Upper Dearne Valley Environmental Trust (UDVET)

Response to Application No. Application 2025/60/93572/E – Land South of Barnsley Road, Upper Cumberworth.

OBJECTIONS, COMMENTS AND OBSERVATIONS

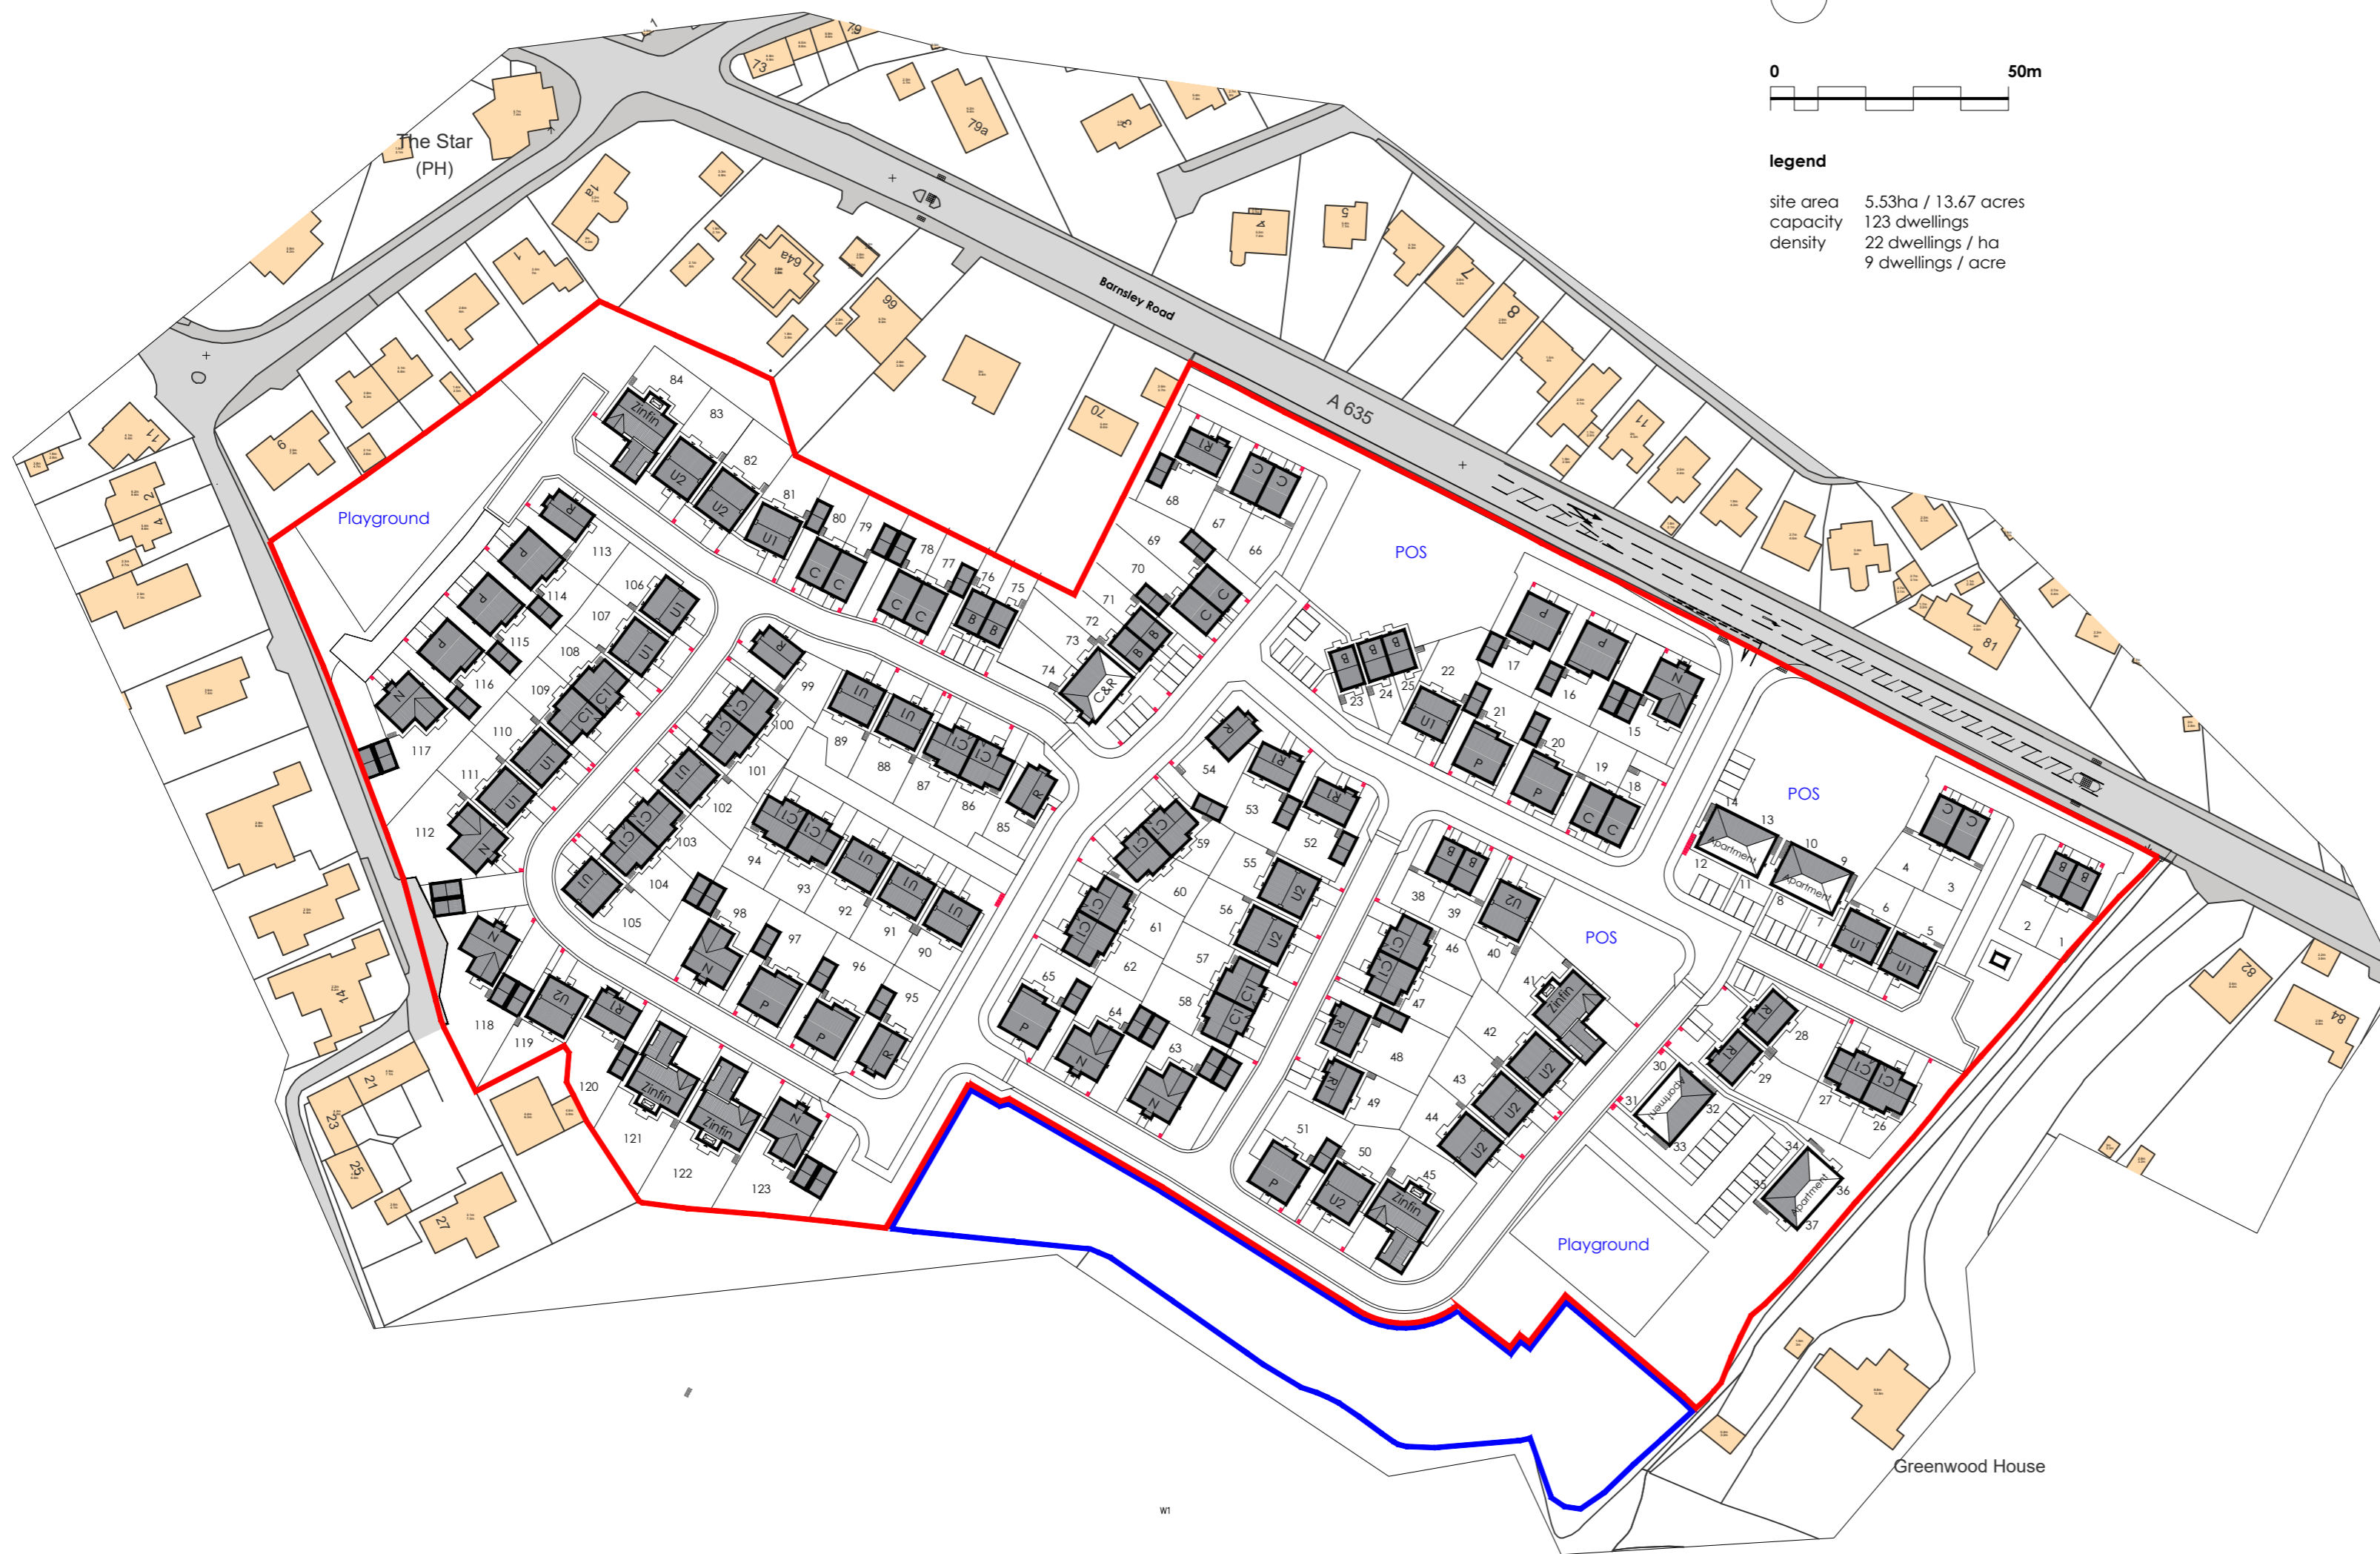
- The application is for 123 houses – **represents a 33% increase in the size of Upper Cumberworth in one go** (currently 663 residents). We understand many LAs recommend only a 10% proportional growth and then staggered so infrastructure can be put in place to cope. Kirklees have already noted that ‘larger areas can accommodate more development’ (Kirklees Publication Draft Local Plan Spatial Development Strategy and Technical Appraisal Paper 2.7). Upper Cumberworth is a car dependent location. Given the lack of local facilities (and distances from required facilities), poor or non-existent above and below ground infrastructure to support such a large population increase, this proposal represents an unsustainable development.

- **Fails to deliver the proportion of affordable homes required** by the NPPF, Para 157 i.e. 35% affordable homes in the case of Kirklees. This means the provision of at least 43 dwellings NOT 19.

- The depth of the buffer zone around the ancient woodland i.e. 15m is insufficient. We understand that the West Yorkshire Combined Authority (WYCA) are bringing in a 50m zone requirement in March, 2026 in line with Woodland Trust recommendations. Kirklees should be seen to conform to this new requirement which we would support as an absolute minimum.

- **Fails to comply with Kirklees Highway Design Guide SPD, Para 5.4 Key Design Driver 20** where one designated visitor parking space should be provided for every 4 dwellings. Therefore, **plans need to show 31 visitor parking spaces** on a development of 123 dwellings. There are many 'local residential streets (Type B)' and 'shared surface streets (Type C)' which need to include laybys and/or localised street widening to accommodate the required visitor parking.

- There appears to be much front of property car parking and very few side of property driveways, creating ugly and congested street scenes thus **failing to comply with Kirklees Highway Design Guide SPD, para 5.14, Key Design Driver 23 and Kirklees Housebuilders Design Guide SPD, Para 7.15.**

- Access for RCVs and emergency vehicles appears to be extremely tight on roads within the development which reduce significantly in width and includes extremely tight bends around which vision will be limited. Drawing A 1073, rev.P14 attempts to show some swept path and turning tracks. The tracking on the bends appear to show overrun onto driveways and the turning manoeuvre at a 'T' shaped cul de sac head extremely complex and awkward. One wrongly parked car (and given the lack of visitor parking spaces highly likely) will block access. As such we believe these plans **fail to comply with Kirklees Highway Design Guide Para 6.4, Key Design Driver 26.**

- The Environmental Protection Act and Fields in Trust Standards requires that equipped play areas will need a 20m buffer from garden boundaries not the property itself. **Plans appear to fail to meet this requirement.**

- A group of houses in top western section of the development **fail to follow the natural contour lines and topography of the site required by Kirklees Housebuilders Design Guide SPD, Para 6.3**
